## SUMMARY OF CHANGES

Project Name: Western Sydney University  
Indigenous Centre of Excellence

Project No.: 23-032  
Date: 23-Oct-25  
Status: Tender Issue - 50% DD (Redesign)

DRAWING TITLE
PROPOSED ROOF PLAN

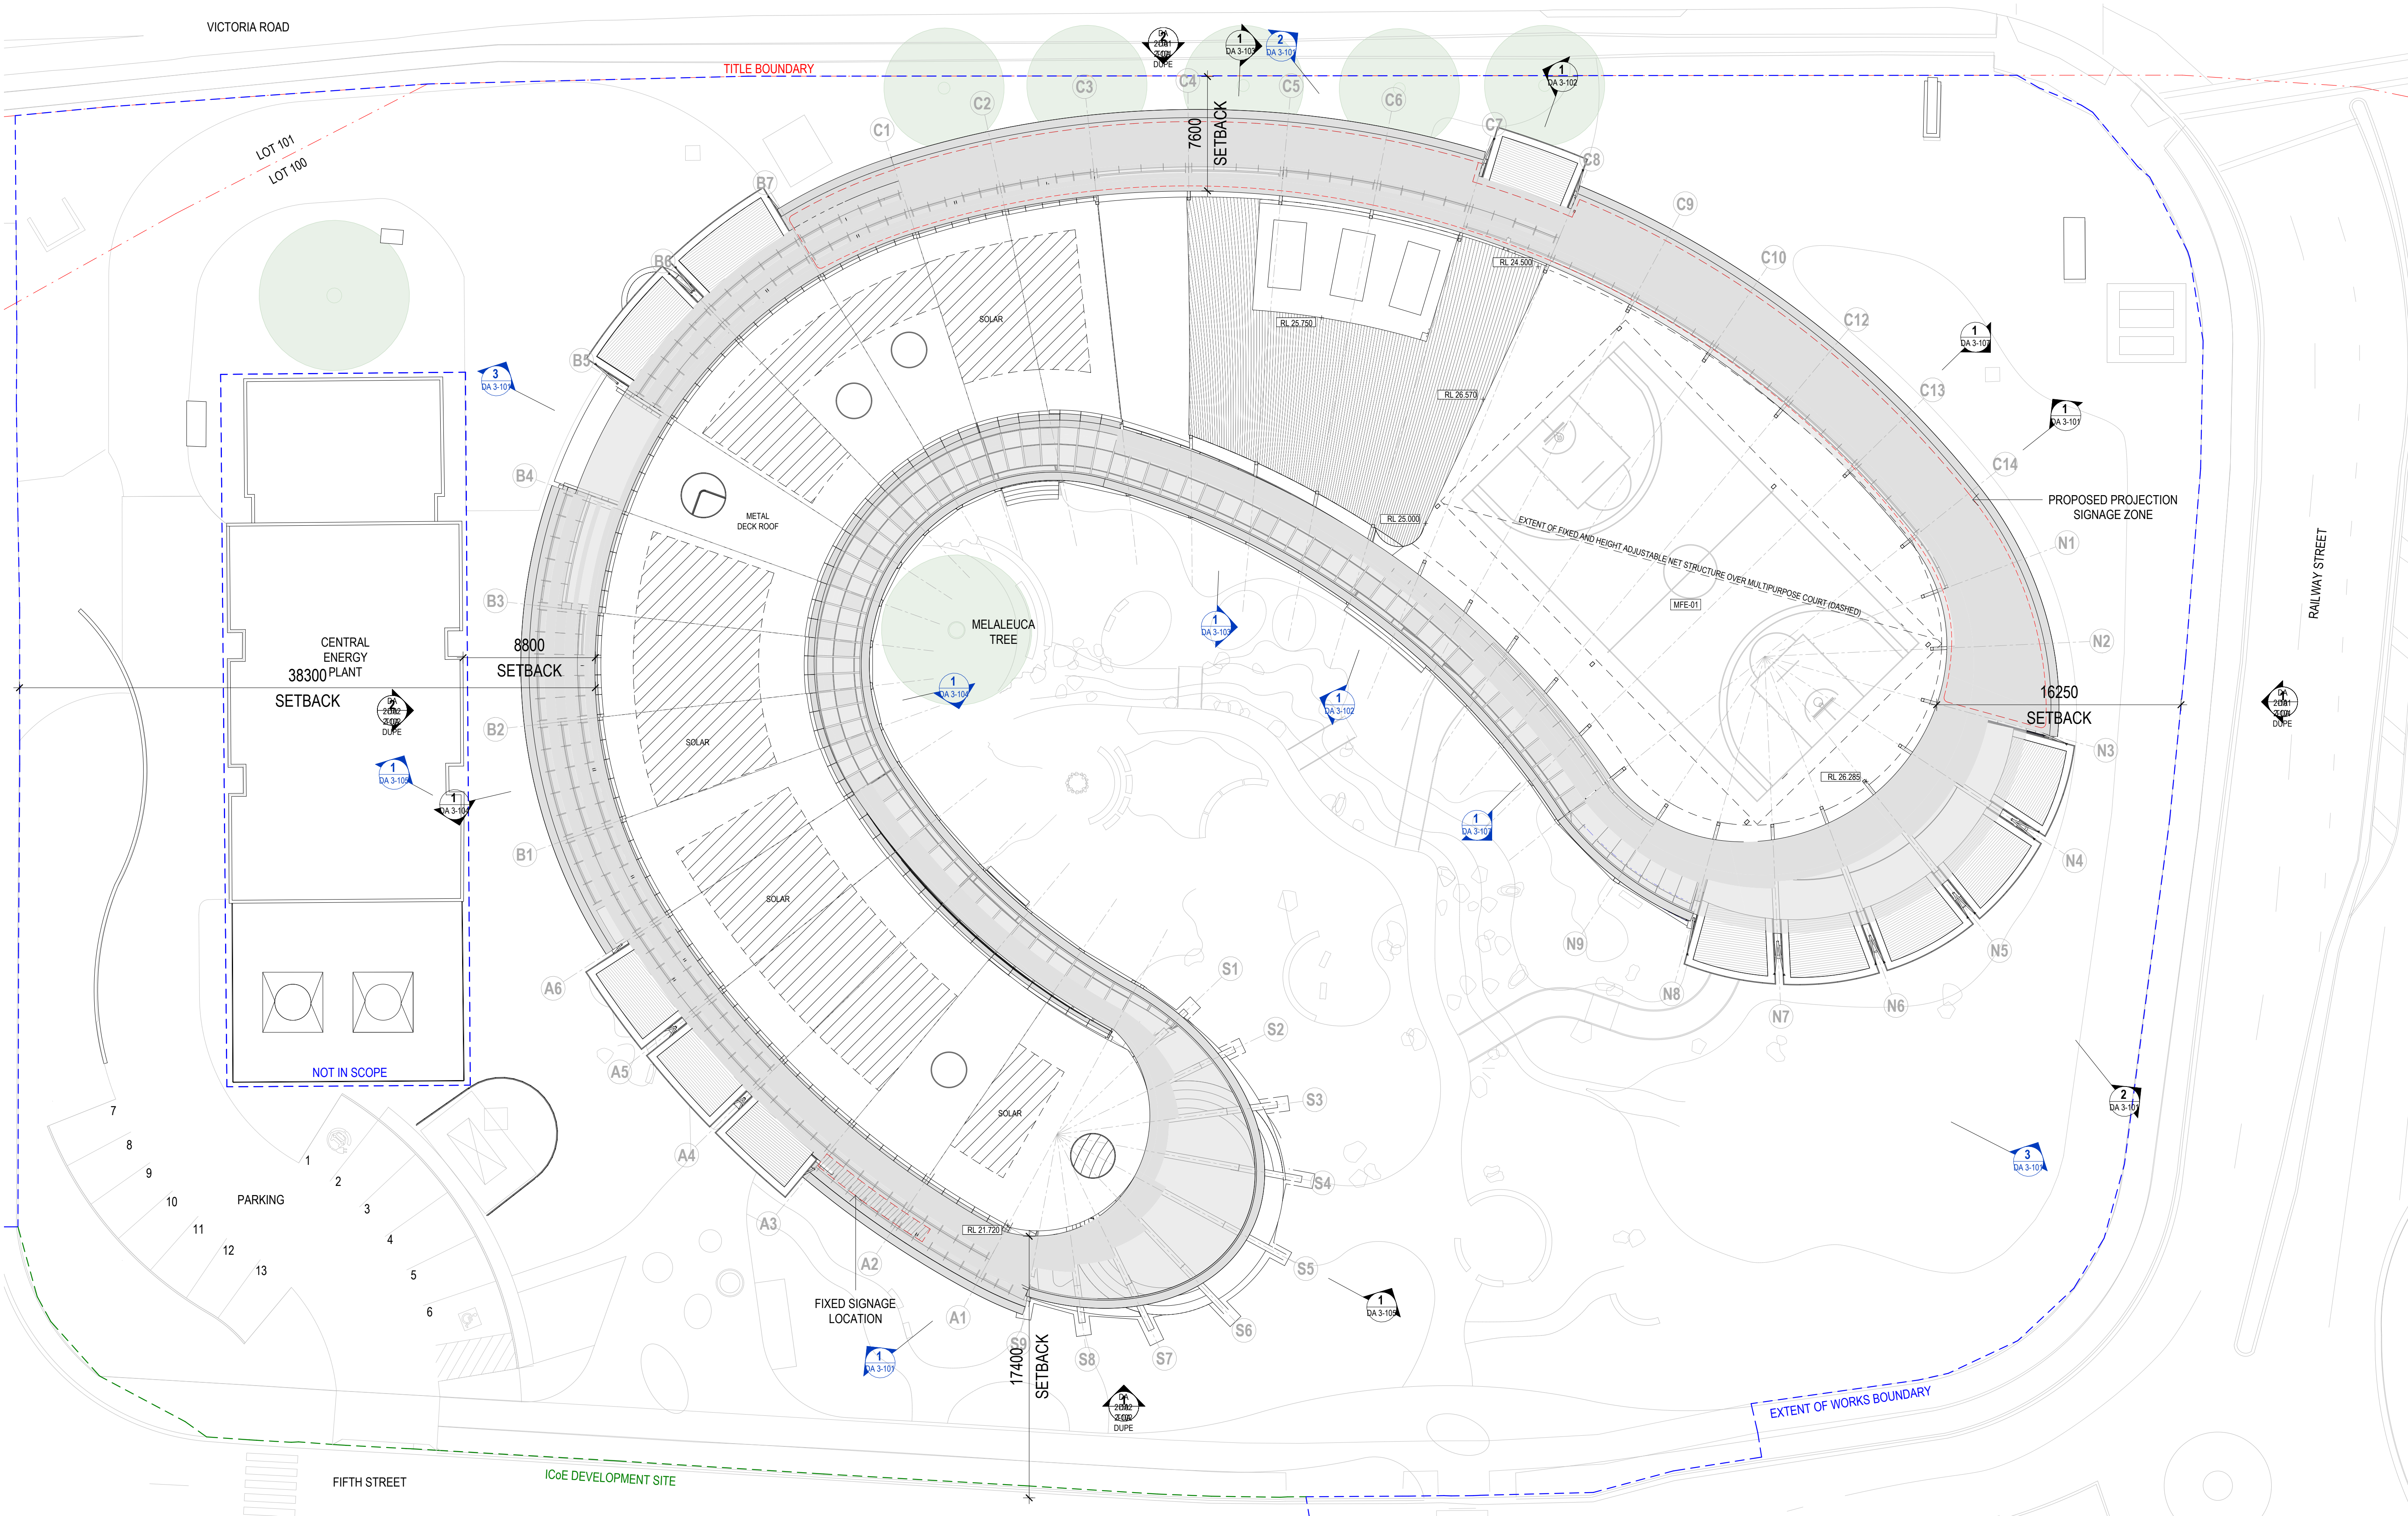
Roof	Façade	Rationalised through the following: - Single roof plane with uniform pitch, fall and springing height - Provision of eaves gutters (in lieu of box gutters, sumps and internalised downpipes) - Deletion of fabricated steel overflow U-channel - Deletion of insulated parapet above roof line - <del>Deletion of skylights/rooflights</del>
	Glazed Facades Rationalisation	Façade	Rationalisation of glazed facades through the following: - Provision of vertical glazing to theatre nose (in lieu of tiered glazing arrangement) - Provision of straight glazed façade elements to Community & Arrival and Amphitheatre (in lieu of faceted glazing) - Deletion of manually and automated raking operable louvre windows - Provision of vertical glazed windows and manually operated casement window types to outer facade (in lieu of raking operable louvres) - Reduction of glazed facade area - <del>Deletion of triangulated glazing</del>

DRAWING TITLE
NORTH AND EAST ELEVATION

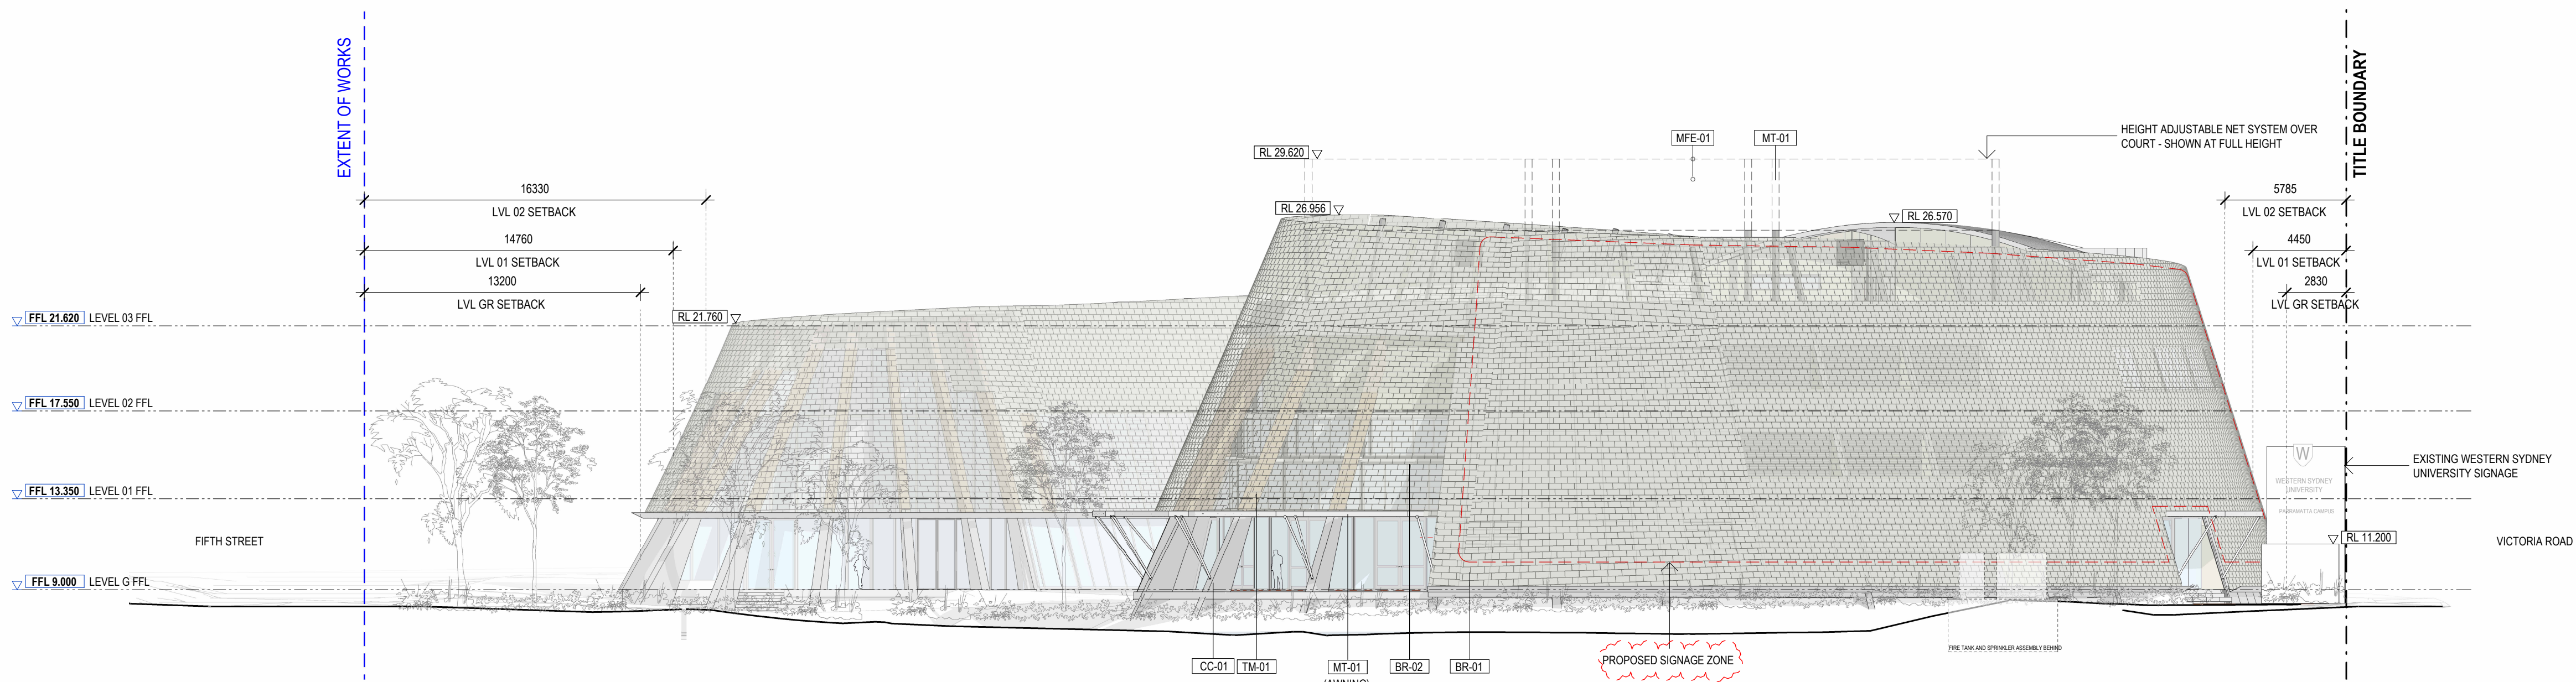
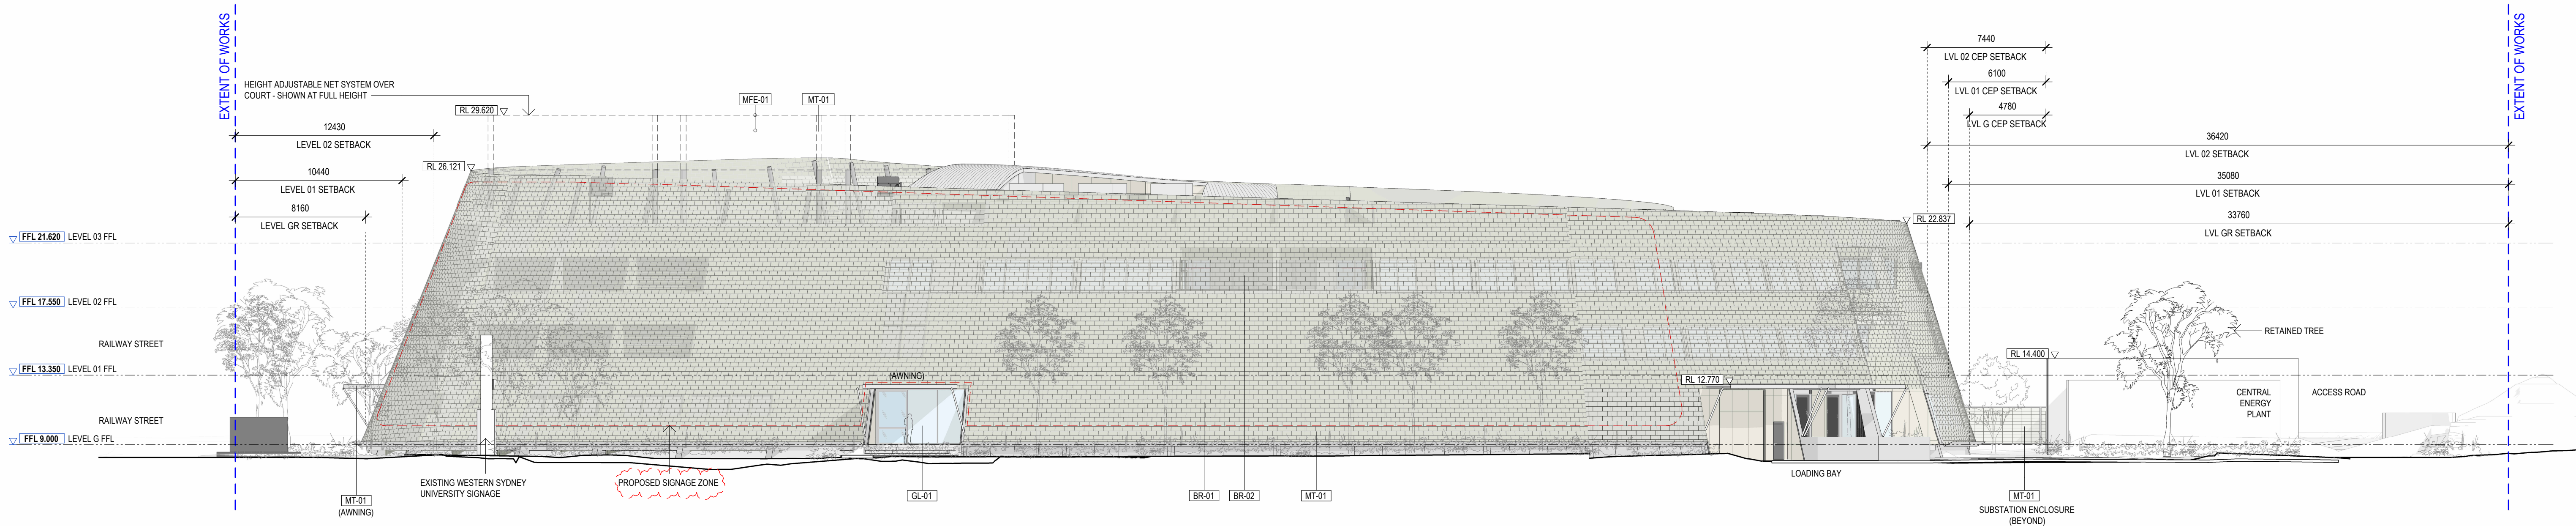
Outdoor Maker Courtyard / External Stair		Deleted Note: internal stair required in lieu of external stair
	Solid Façade Types		Reduction of EF-01 (High-density fibre cement panel)
	Awnings/Canopies	Façade	Reduced area and number
	Entrances	Façade	Deletion of 2x entry points along inner courtyard façade
